**CITY OF PORTLAND, MAINE  
DEVELOPMENT REVIEW APPLICATION  
PLANNING DEPARTMENT PROCESSING FORM  
DRC Copy**

**English Nancy**  
Applicant  
**40 Park Ave, Portland, ME 04101**  
Applicant's Mailing Address

*ex. S.F.* **40 - 40 Park Ave, Portland, Maine**  
Address of Proposed Site  
**036 D004001**  
Assessor's Reference: Chart-Block-Lot

Proposed Development (check all that apply):  New Building  Building Addition  Change Of Use  Residential  Office  Retail  
 Manufacturing  Warehouse/Distribution  Parking Lot  Other (specify) **carriage house to single fam.**

A 1.3

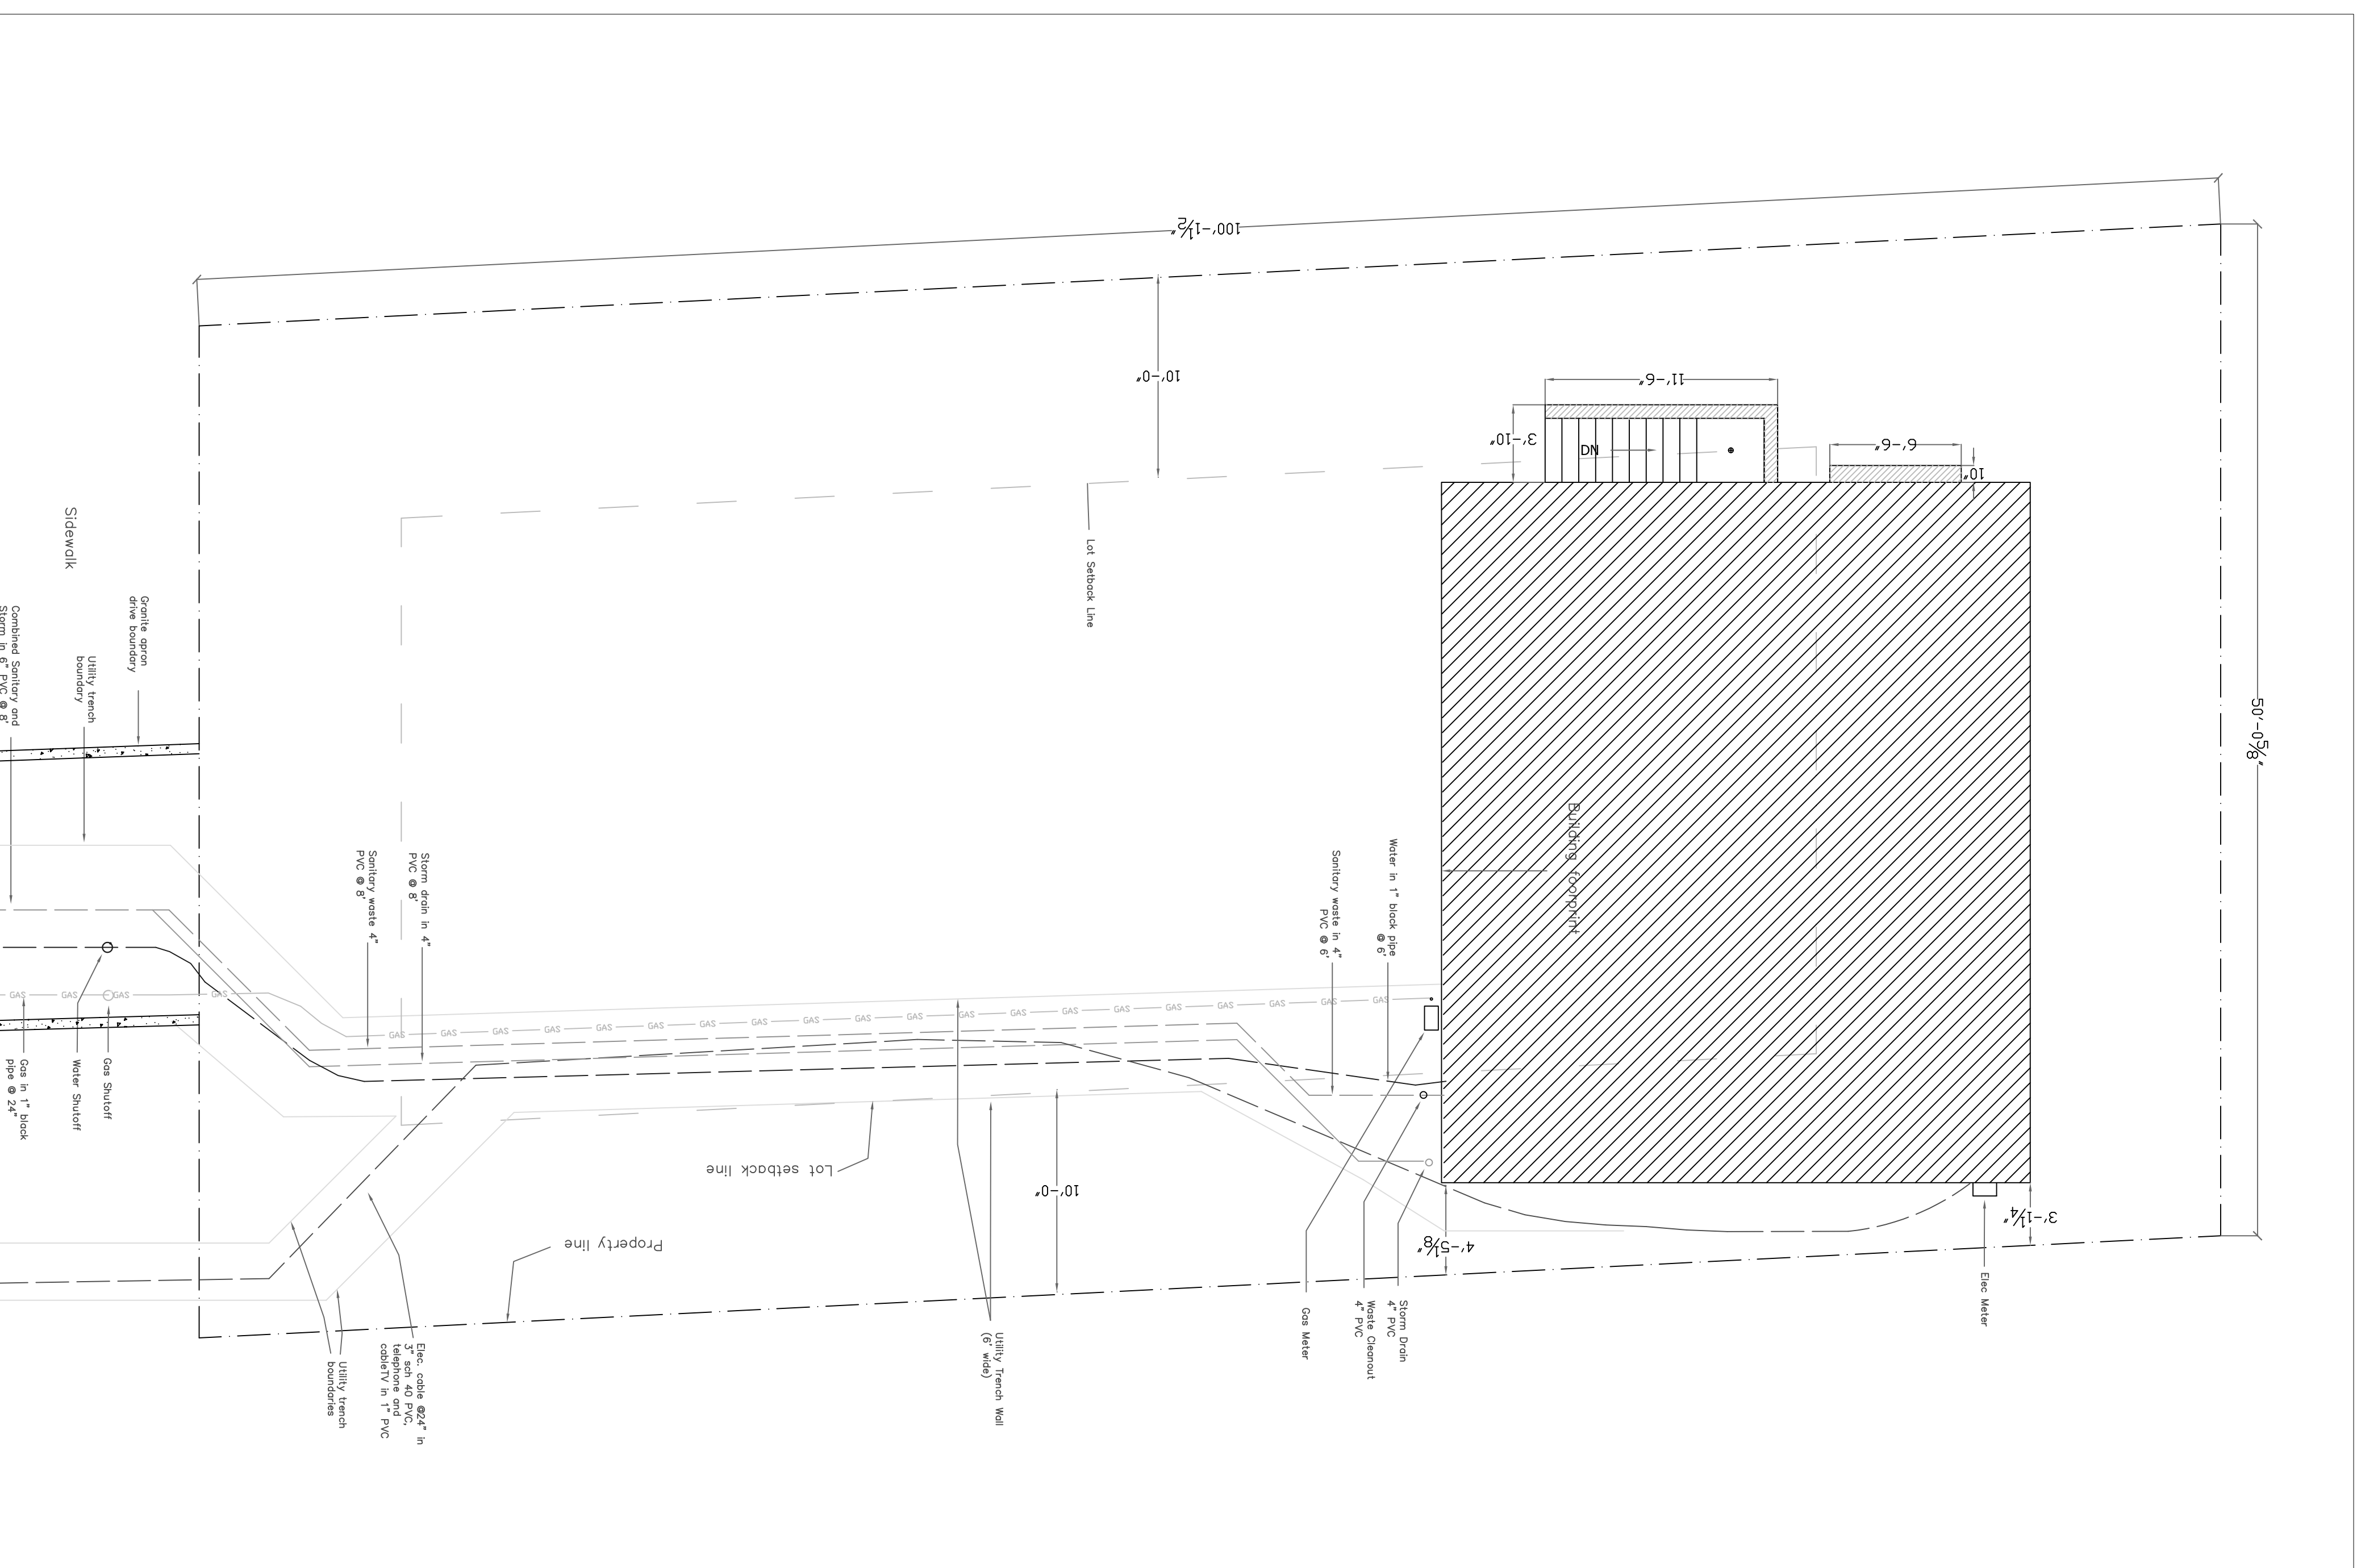
I'VE ALTERED THE MASONRY WALL  
PLACEMENT AS NOTED ON THE DRAWING,  
ALLOWING FOR 2 ANGLED PARKING SPOTS  
INSIDE THE 10' SETBACK. NOTHING ELSE  
ON THE DRAWING HAS CHANGED. PLEASE  
LET ME KNOW IF THIS IS ACCEPTABLE.
